2026/CLASS MA/91970

10, Commercial Road, Skelmanthorpe, Huddersfield, HD8 9DA

There are primary rules and criteria for utilising Class MA prior approval application and this submission fails to meet with these requirements and as such should be dismissed.

SECOND FLOOR PLAN

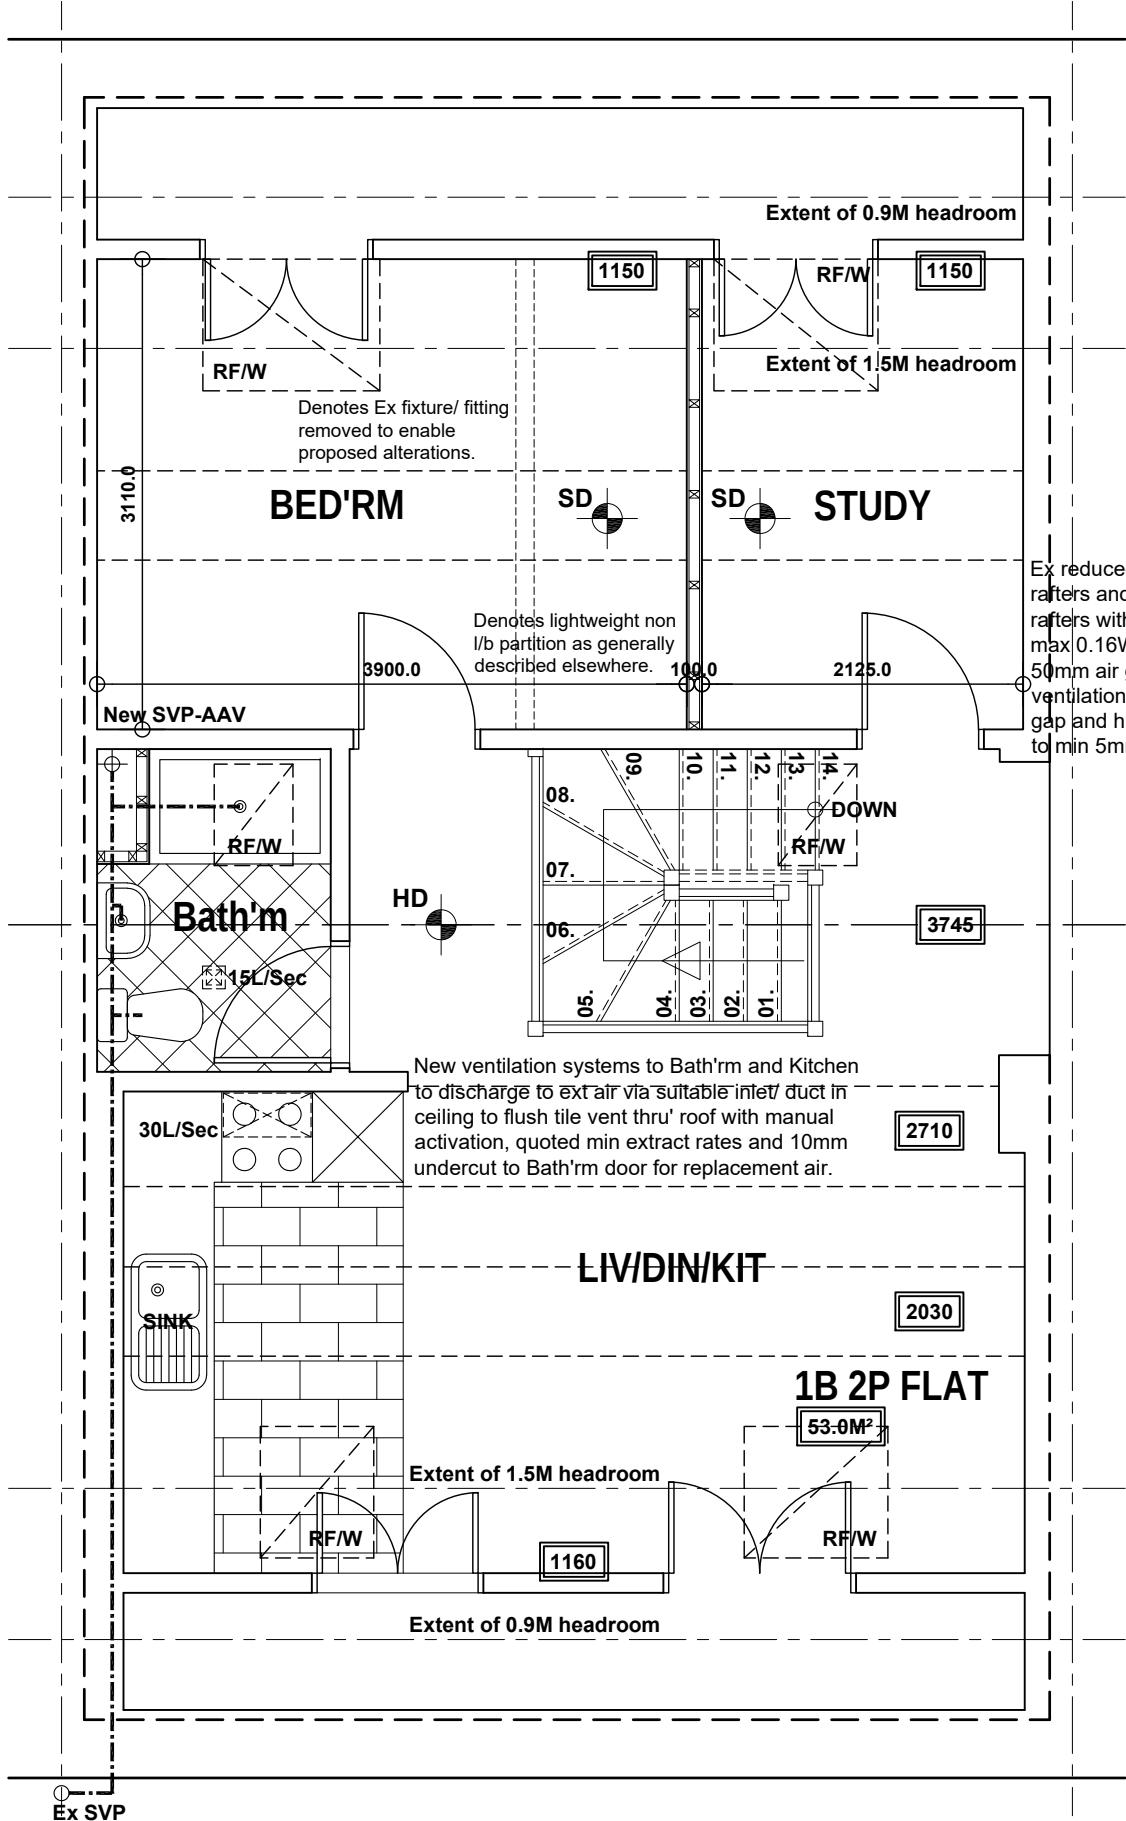
The floor area falls way below the requirements set out by the national described space standards. On the floor plan there is a clear indication where the 1.5m headroom can be achieved, and the floor plan extends beyond this zone. The drawings show a floor area of 53m² and this area includes the space beyond the 1.5m headroom. The NDSS clearly stipulates that these areas are not included within the Gross Internal Floor Areas (GIFA). Working within the NDSS guidance and discounting the floor area with a clearance of less than 1.5m the actual GIFA is 45.94m² and therefore fails to meet this standard.

In addition to the above assessment, it is evident on the drawings that any necessary thermal, acoustic and fire upgrades to the external walls have been left off the drawings. Once these are introduced the additional wall thickness will reduce the GIA further still.

On the plans, the applicant has shown a study, which lead me to believe this will be used as a second bedroom and has been shown as a study due to the room size restrictions. It's unusual to have a study in such a small dwelling and at the expense of providing more space within the main bedroom.

No bathroom has been provided, only a small shower room more associated with a studio space.

The same is also true for the double bedroom where the floor area will be 9.81m² when taking into account the reduction of the headroom. This fails to achieve the required 11.5m² and therefore fails to meet this standard.

No storage space has been indicated on the plans. The eaves areas with low level doors would suggest storage areas, but as these are below 900mm in height these cannot be included within the calculations, and additional storage should be shown.

On the layout the current floor area with a floor to ceiling height greater than 2.3m is 28sq.m. As a minimum for a compliant one-bedroom dwelling this should be at least 37.5sq.m. Therefore, the proposals fail on this NDSS Technical Requirement

The proposed dwelling relies exclusively on rooflights for its natural light. The submitted plans indicate a total of six rooflights of varying sizes, providing a combined glazing area of approximately 4.5m². This equates to less than 10% of the proposed overall floor area, falling

significantly short of the 20% benchmark generally recommended by Building Control for adequate daylight.

Furthermore, the primary habitable space comprising the living, kitchen, and dining area would benefit from merely 1.8m² of glazing. This represents less than 5% of that specific floor area. The reliance on such restricted glazing, coupled with the complete lack of standard windows, means the design fails to provide any meaningful natural daylight or outlook. Consequently, the proposal would result in a heavily compromised living environment and a highly substandard level of residential amenity for future occupiers.

Fire regulations for a dwelling with a floor level over 4.5m from the ground floor will need to provide a protected stairway. The staircase on the upper level is shown to be open plan and therefore fails to comply with Approved Document Part B, in addition, cooking facilities are not remote from the main point of access and will impede the escape route should this area be the source of the fire. The travel distance from the furthest point within the bedroom to the top of the staircase will exceed 9m. For these reasons the layout fails fire safety requirements and will place the future occupiers at risk.
